CITY OF ALBUQUERQUE

February 2, 2022

Re: El Parador Multi-Family Development
201 Yale Blvd SE
Traffic Circulation Layout
Architect's Stamp 01-28-2022 (K15-D107)

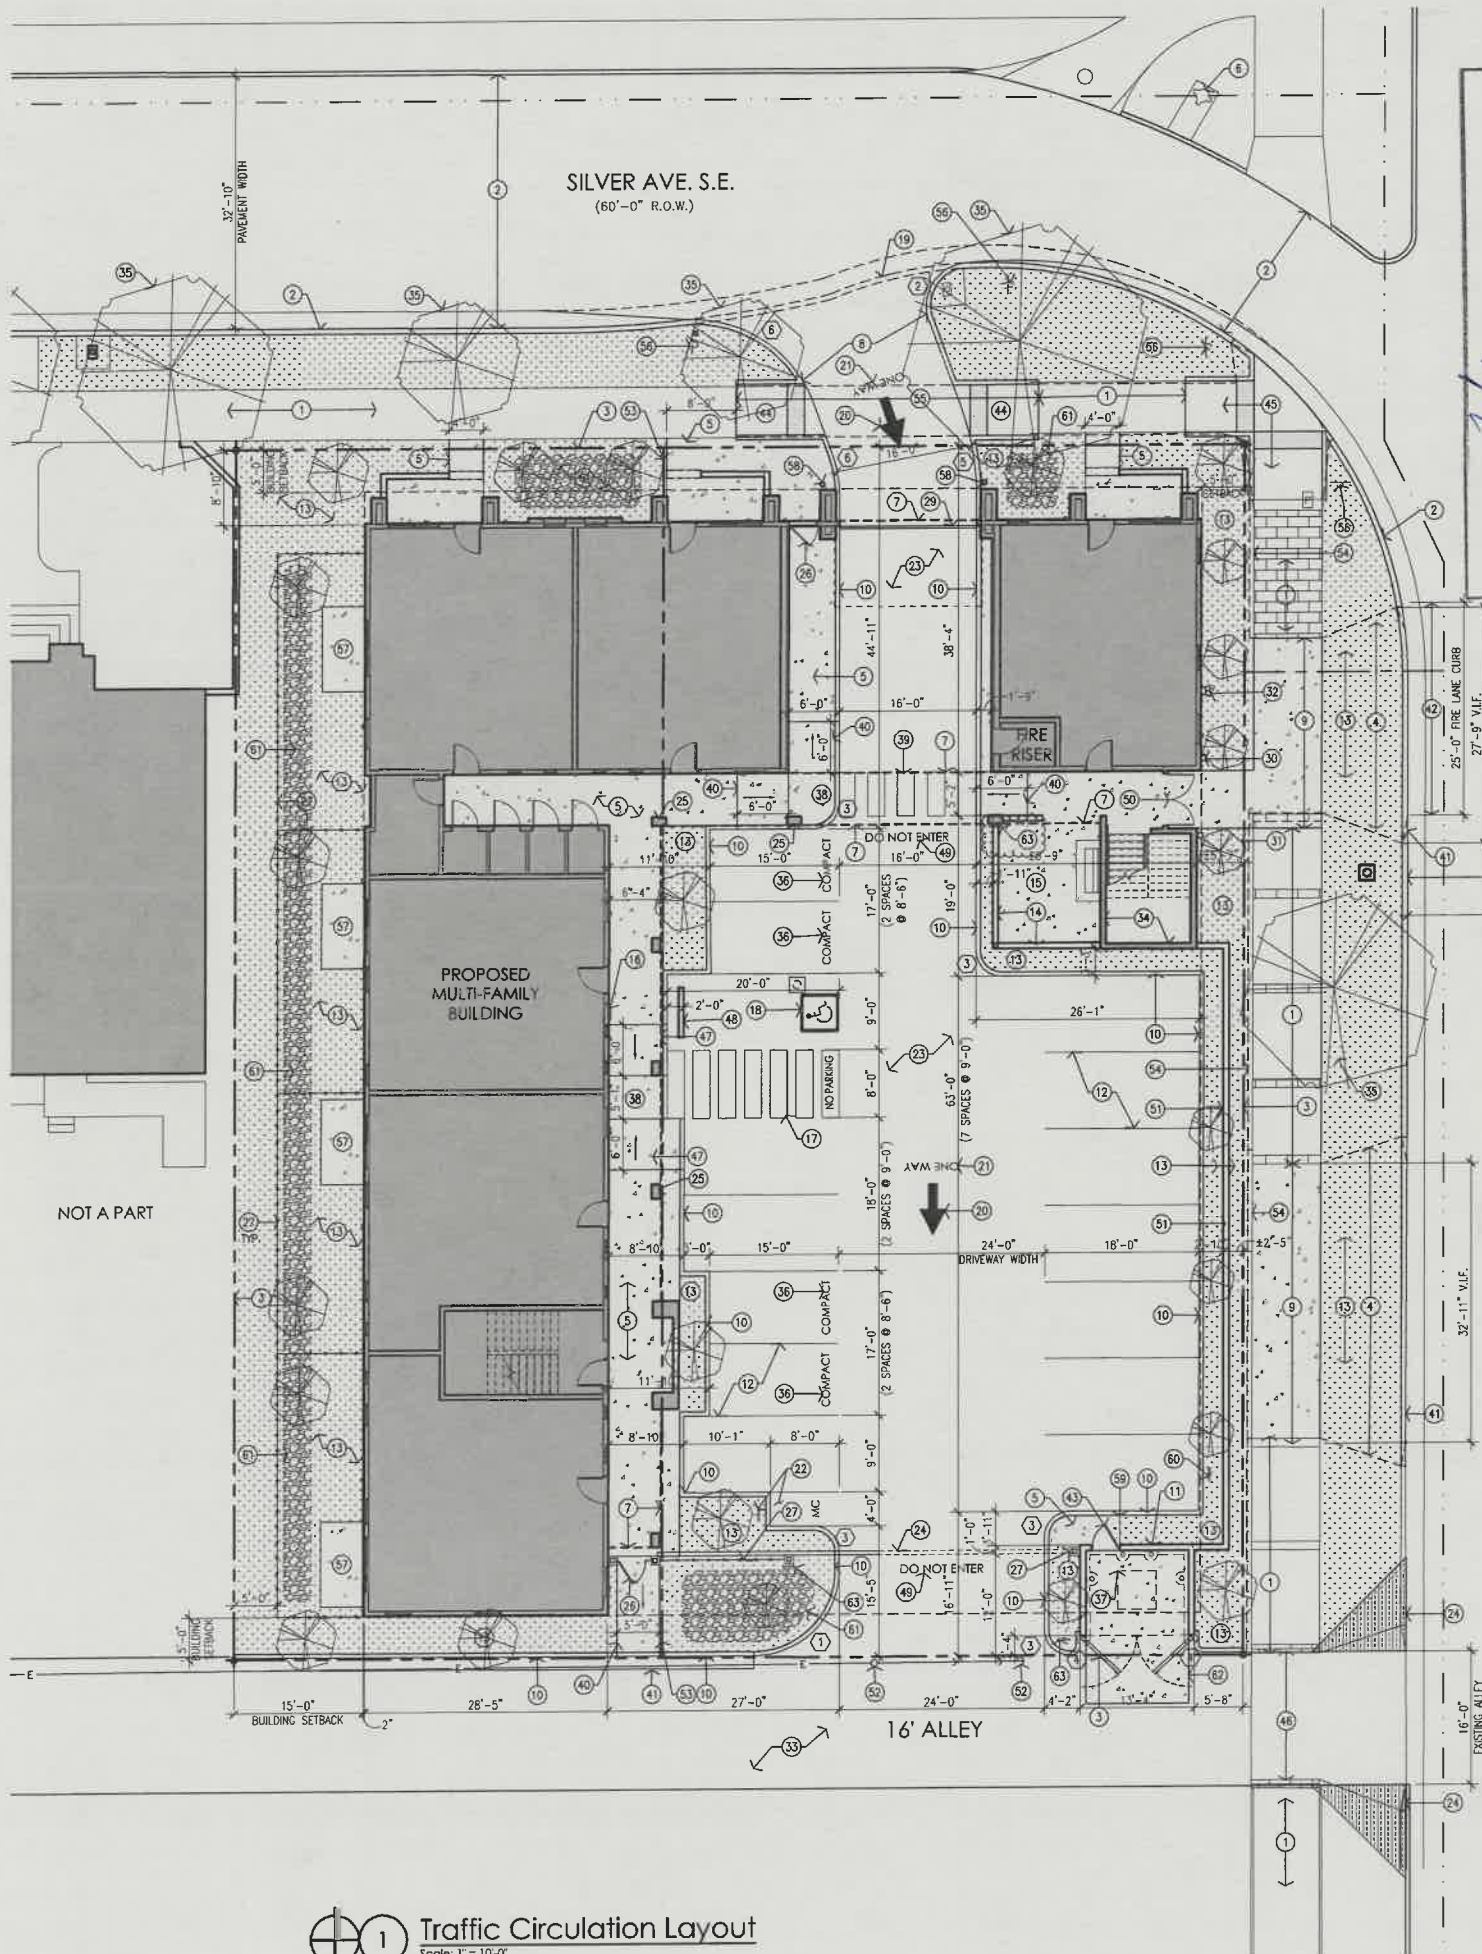
1. **Keyed Note 63 :**

- Keyed note will need to apply adjacent to compact parking at end of do not enter, both sides will need signage.
- Apply signage on both sides not just one side.
